From: Amanda Scholes on behalf of Planning.Responses
Sent: 19 August 2020 10:01
To: Planning Scanning
Subject: FW: FW: Gladwyn EP/62/20/DOC

Yes we would recommend discharge of the condition. Surface water drainage to be constructed in accordance with Drawing 2386_01_13.

Scales: 1:20 1:200 No: 2386/01/13

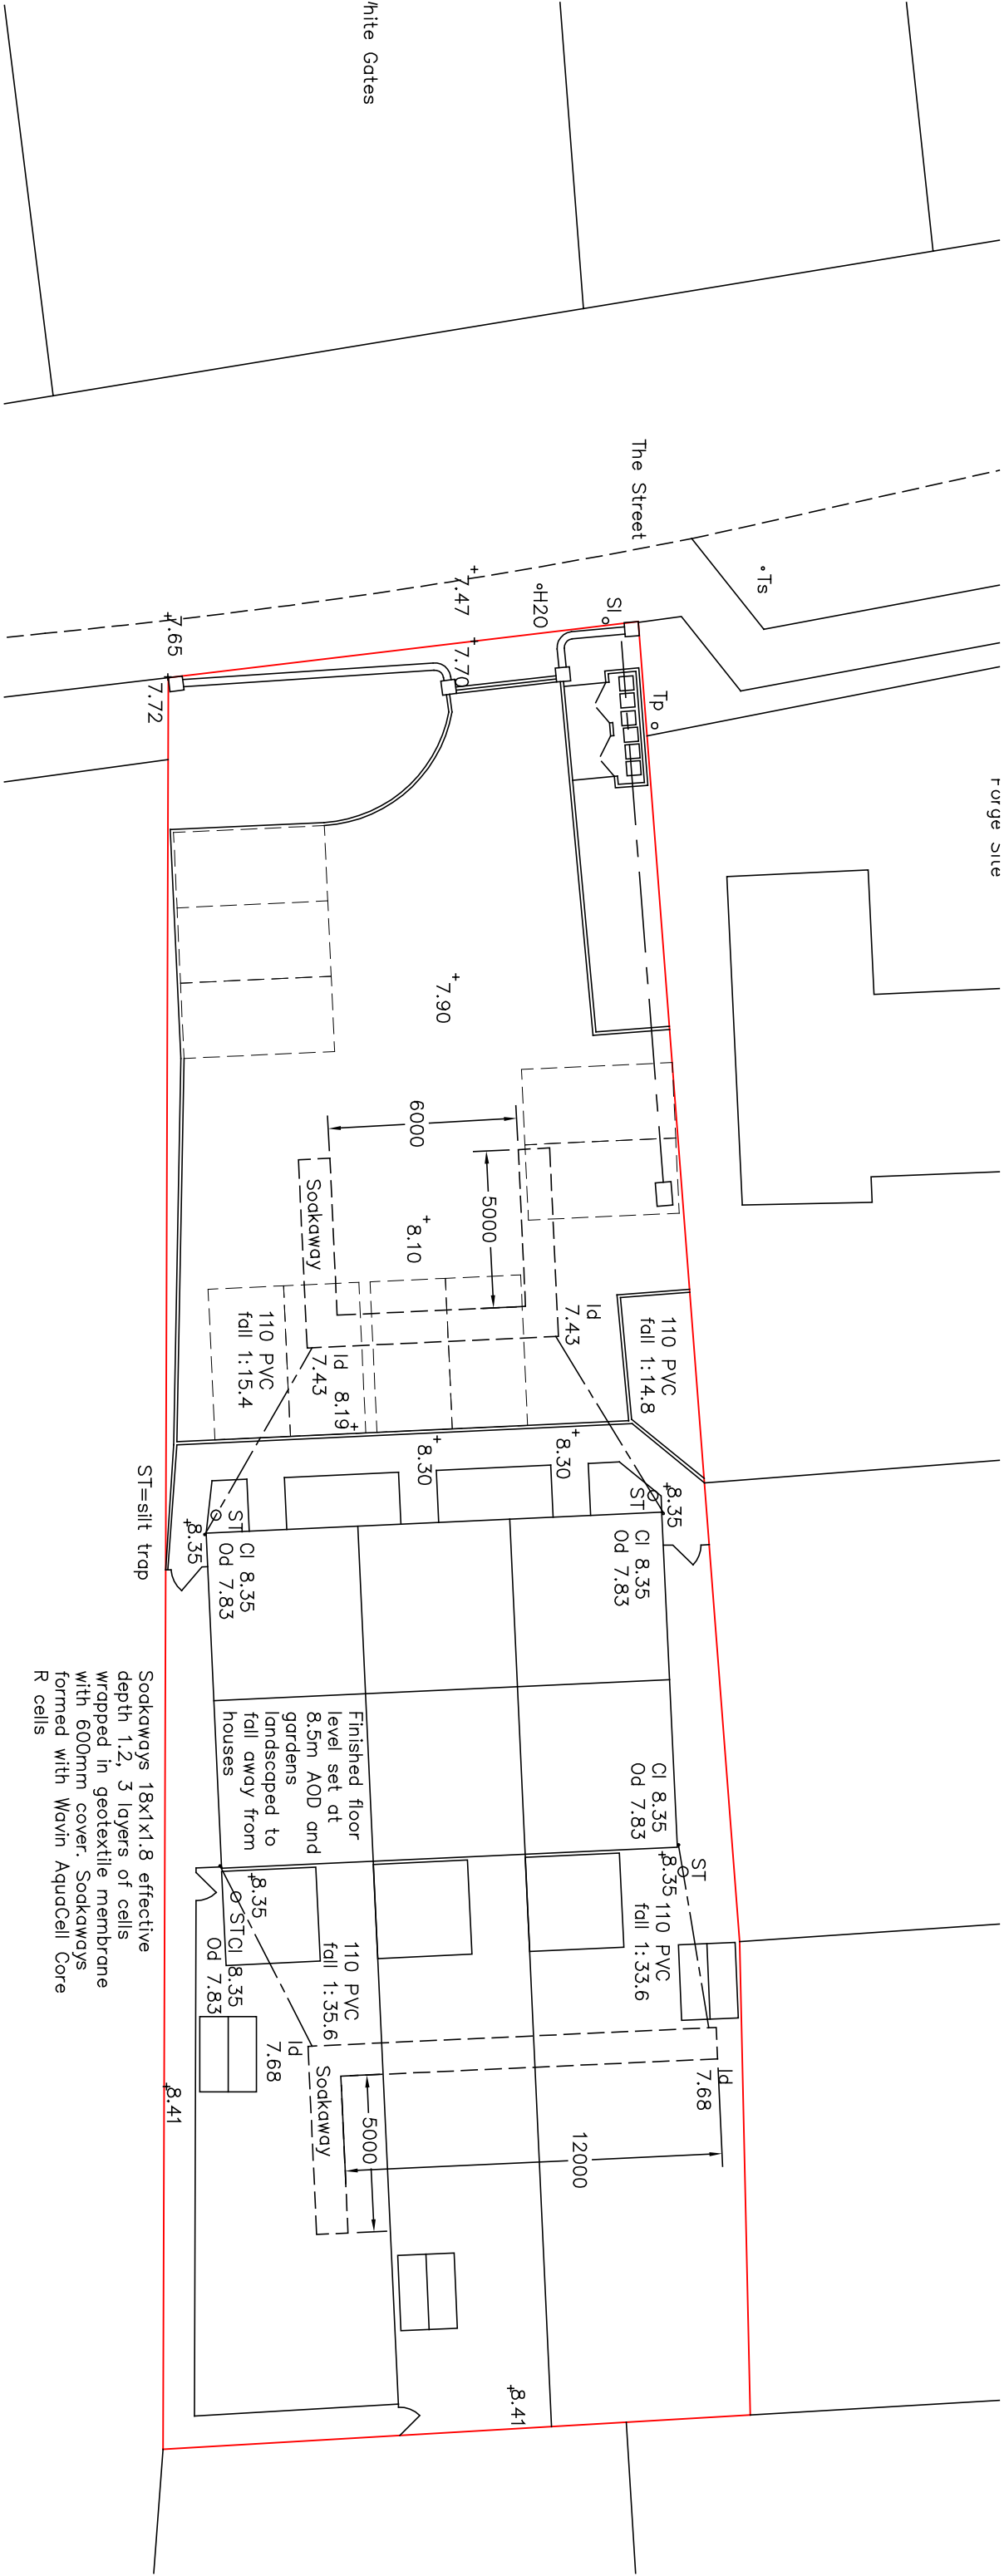
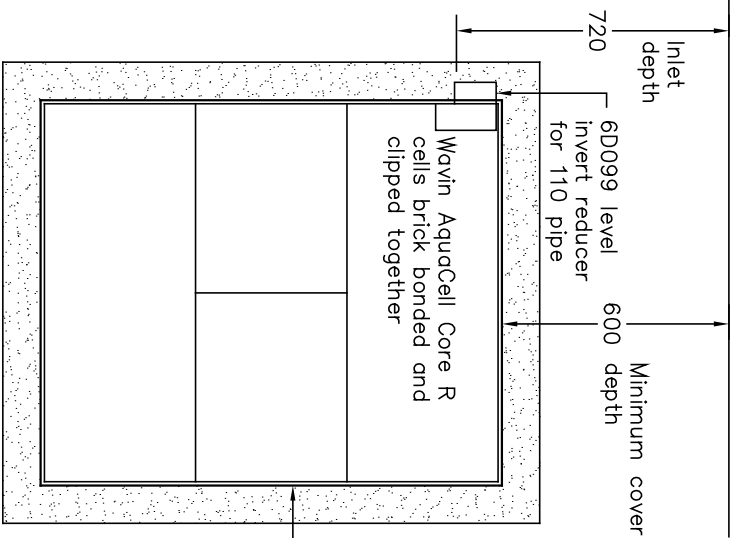
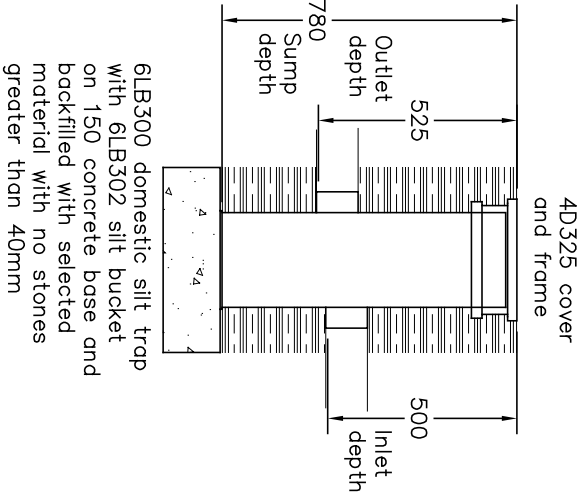
Almost all of my points have been covered off on this one. Unfortunately there are still issues regarding the soakaway and pipe work under the parking area. The drawing states that soakaways have a cover depth of 600mm, yet the west soakaway is laid under the car park. According to the BBA Certificate for the product (Table 9 page 8),

the minimum cover depth under vehicular areas should be 700mm. We would also need to see a concrete bed and surround for the pipes under the parking area (Class Z). Once these issues have been rectified on the drawings I shall be happy to recommend discharge of conditions.
